Our Ref: PT/DIC001/0005
Your Ref: TR0110016

A63 (Castle Street Improvement, Hull) – TR010016
Deadline 2: Response by EPIC (No.2) Limited (“EPIC”)
IP URN: 20018241

A63 CASTLE STREET IMPROVEMENT, HULL
DEVELOPMENT CONSENT ORDER 20[XX]

Note of submissions by EPIC (No.2) Limited to the examination hearings

Drawing Title **LAND PLANS REGULATION 5(2)(i) OPTION A SHEET 3 OF 6**

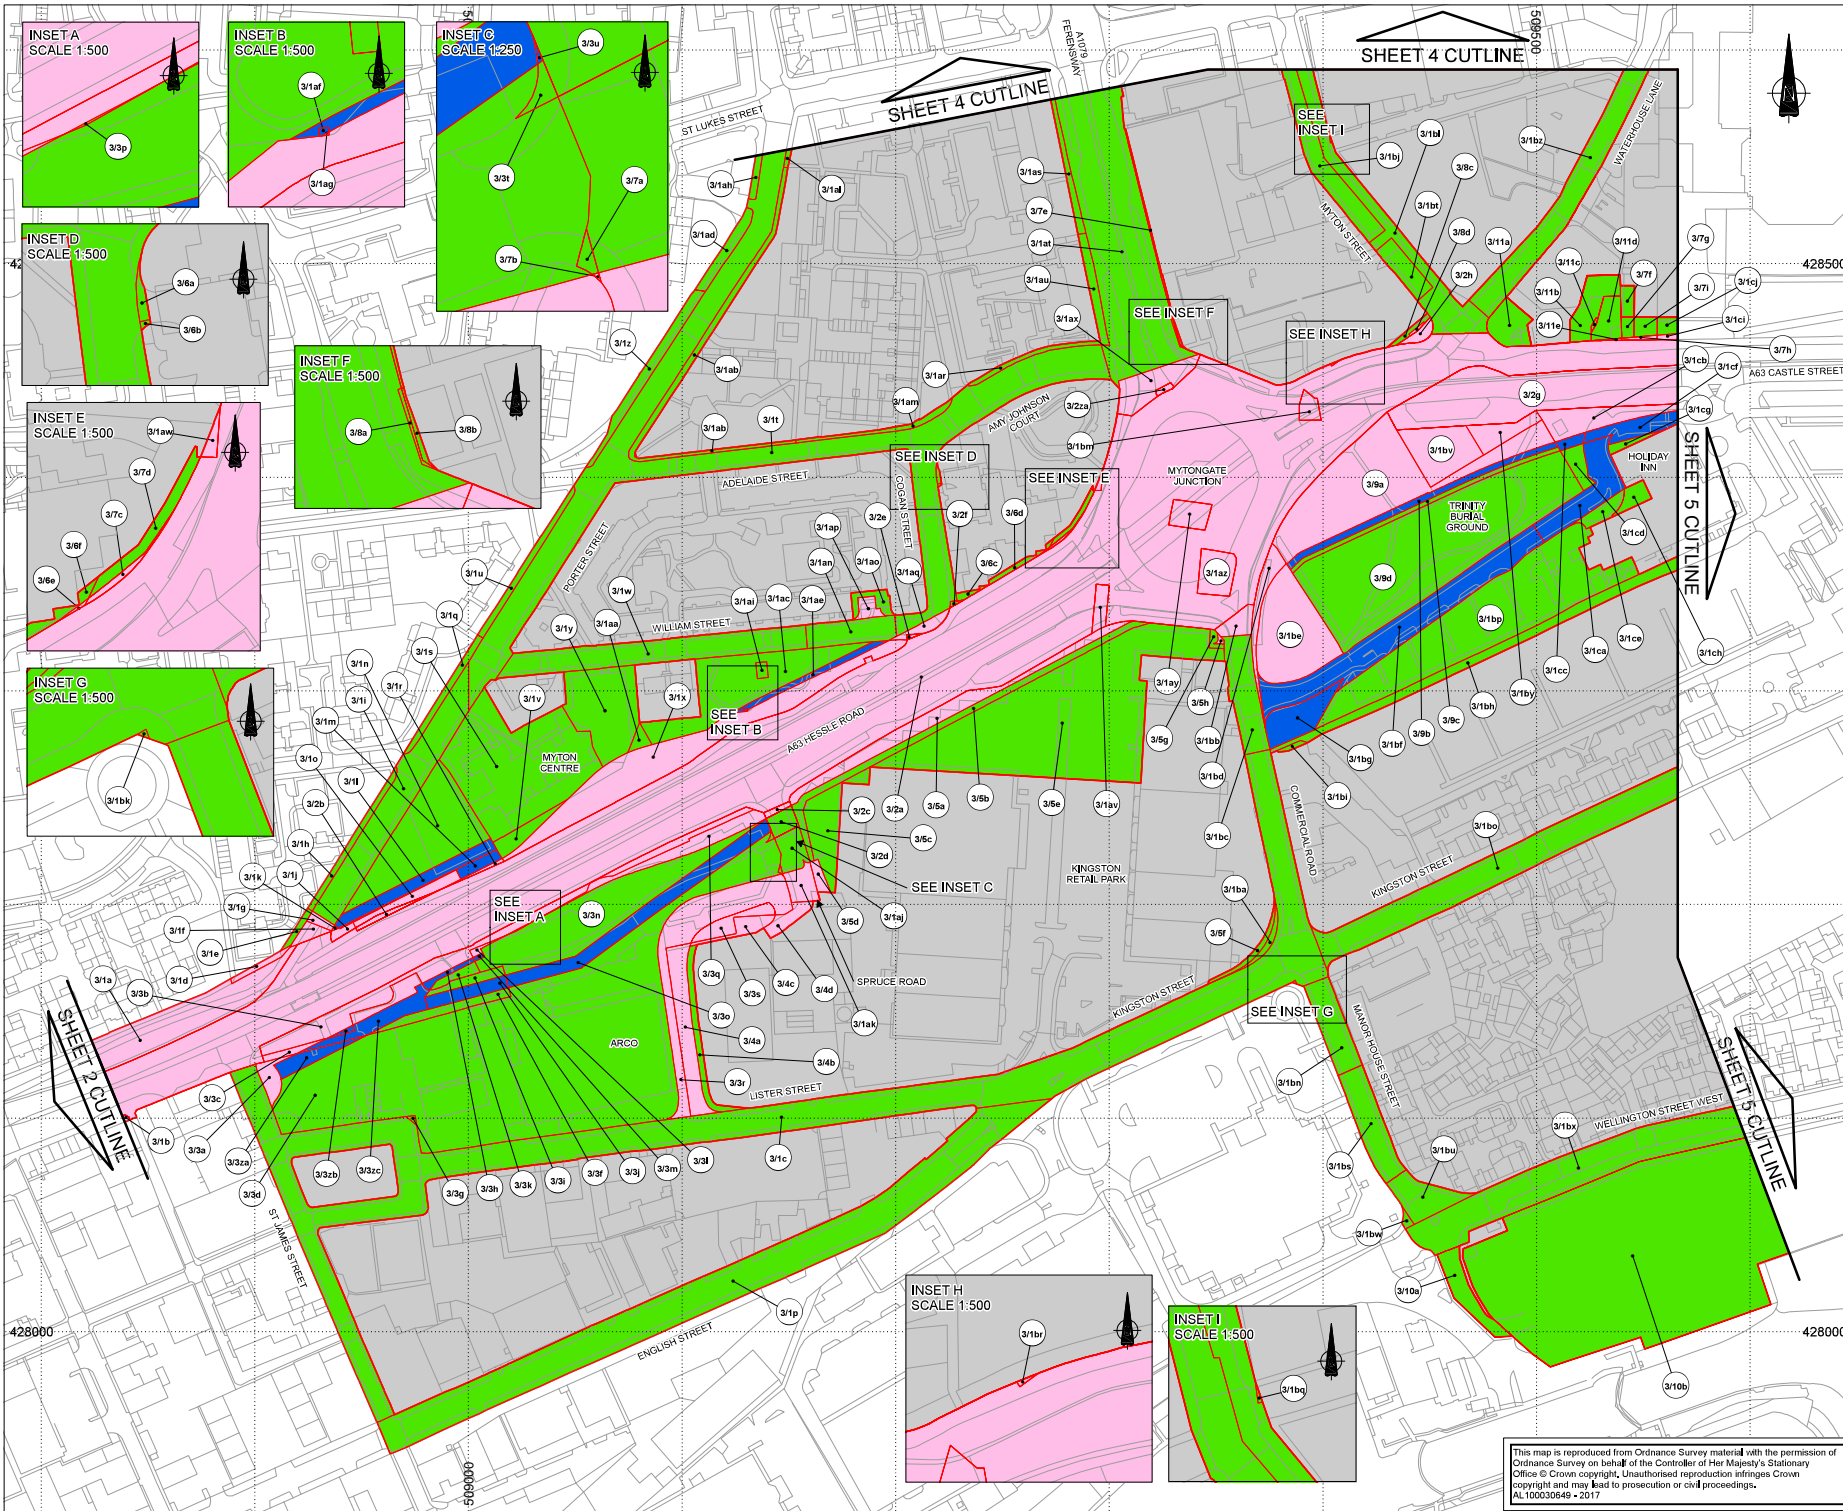
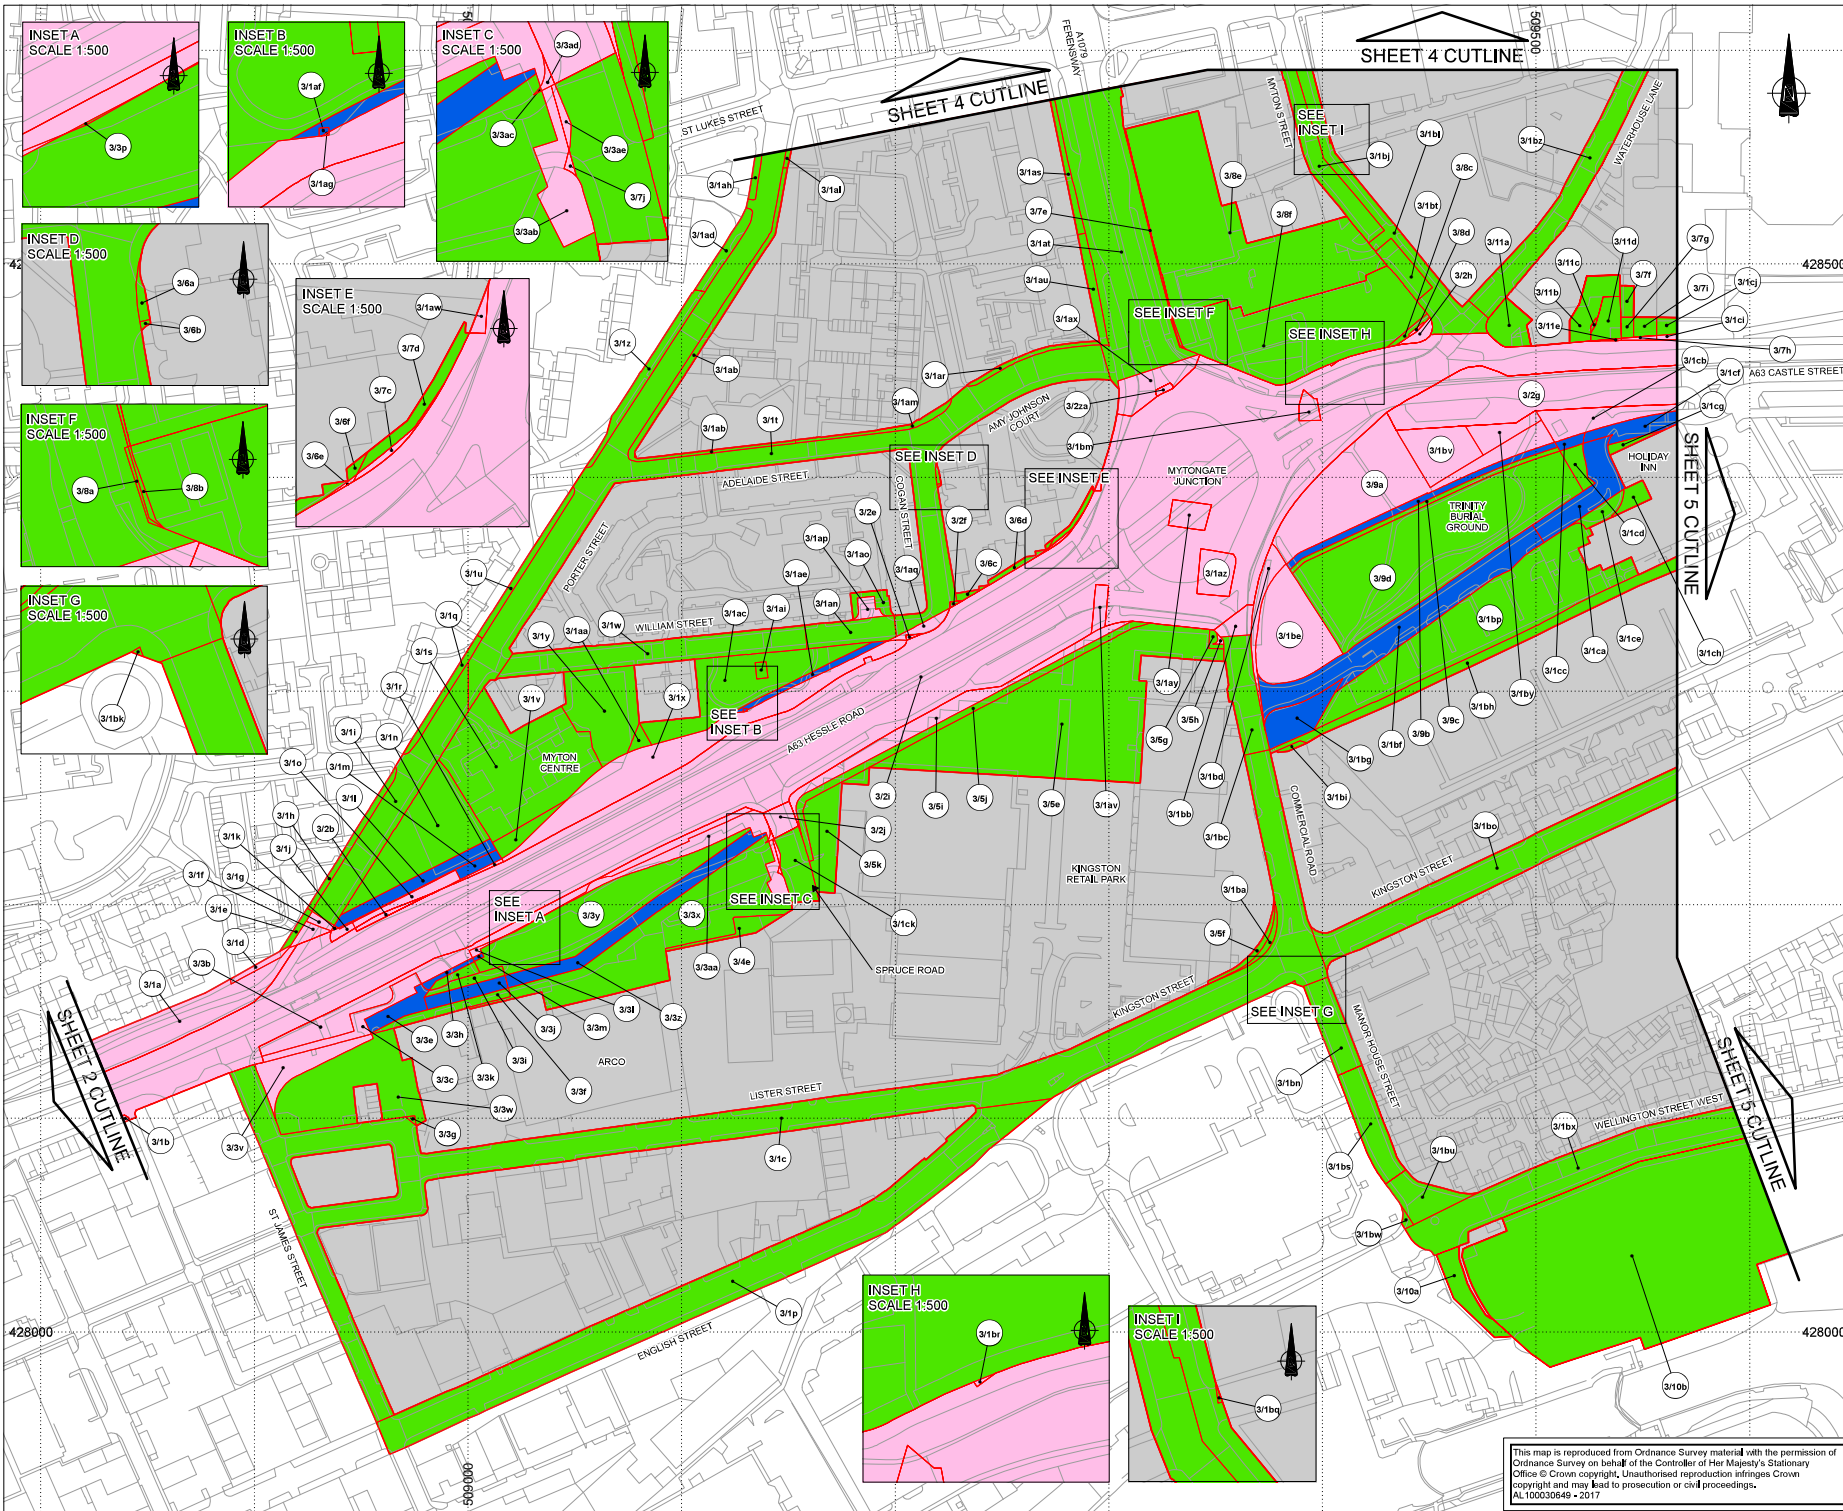
4.1 Schedule 7, Land Plans – Sheet 3:

4.1.1 Leave out the row beginning 3/5b and insert:

3/5b, 3/5j	Working space for the construction of the new Westbound onslip	Work 15
------------	--	---------

4.1.2 The Streets, Rights of Way and Access Plan Sheet 3 to be amended to show a highway being provided for the full width of the access to the western service yard of Kingston Retail Park.
